OBJECTION CM/64/19/PL Langford Horsemere Green Lane

Plot 8 deliberate misrepresentation by applicant to ADC

Planning Objection: CM/64/19/PL Langford, Horsemere Green Lane BN17 5QZ

Drawing Title:
HOUSE TYPE-F1
FLOOR PLANS

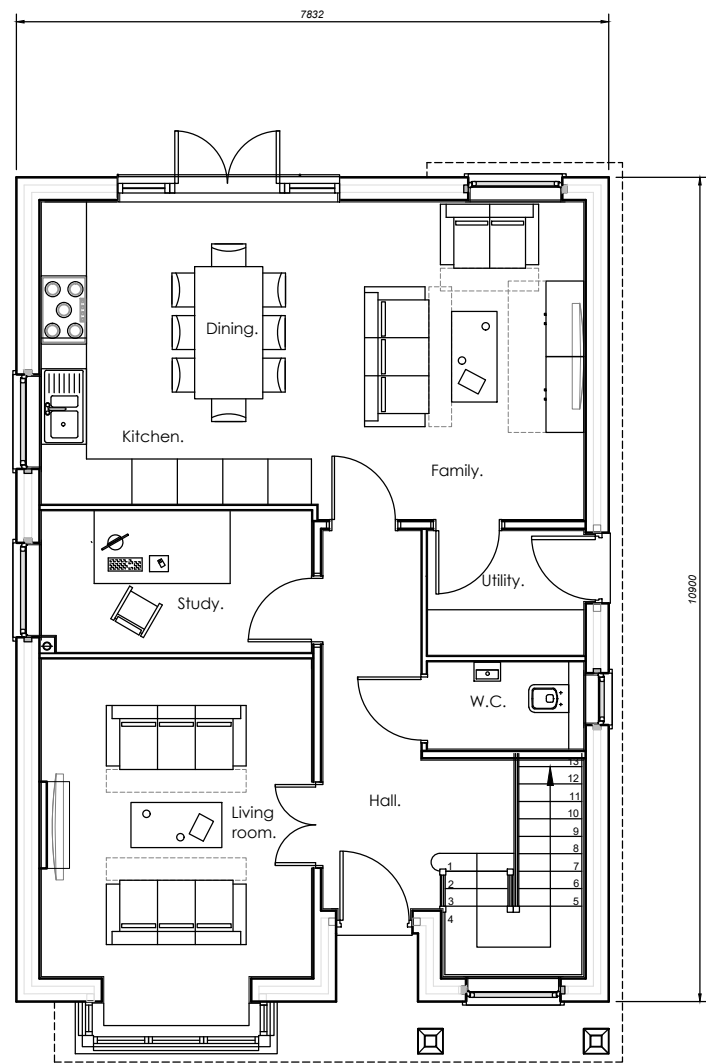
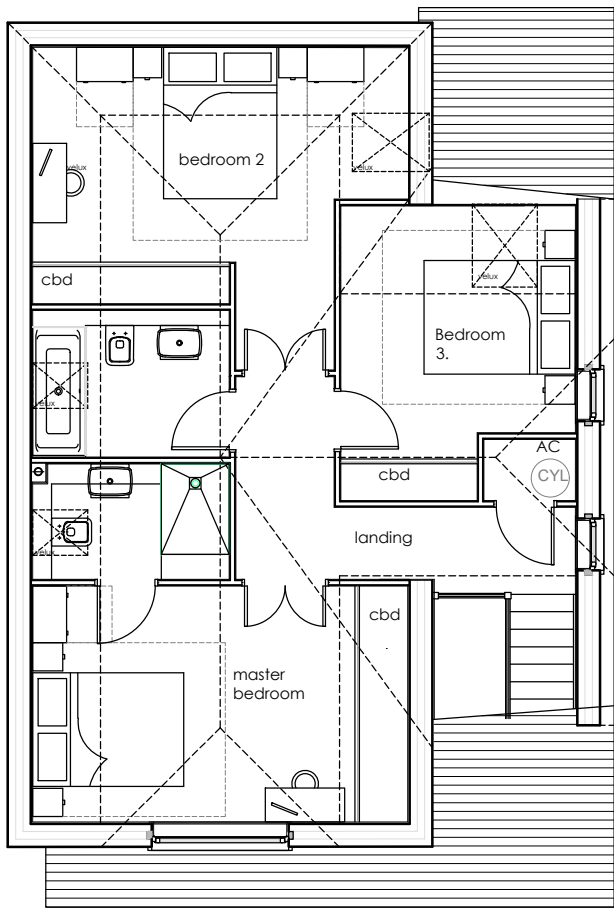
3. The value of my property has been badly affected.
4. PLOT 8 runs the length of my boundary. An application for a 4-bed house type E has been superseded by House type F described as a **3-bed BUNGALOW**. Having looked at the plans this is a **HOUSE** with 2 bedrooms and 2 bathrooms on the first floor, and one bedroom on ground floor. The whole length of the proposed house runs the whole length of my boundary, with permanent structure within feet of my fence. This is very intrusive, and will obliterate light for the majority of the day, completely unacceptable. I speak on behalf of myself and my affected neighbours.

6. If the applicant were to reduce the roof height to single storey, ie, that of a bungalow, as proposed, and lower the ground level, this would fall in line with their proposal of '**2 x 3-bed bungalows**' made to Arun District Council.
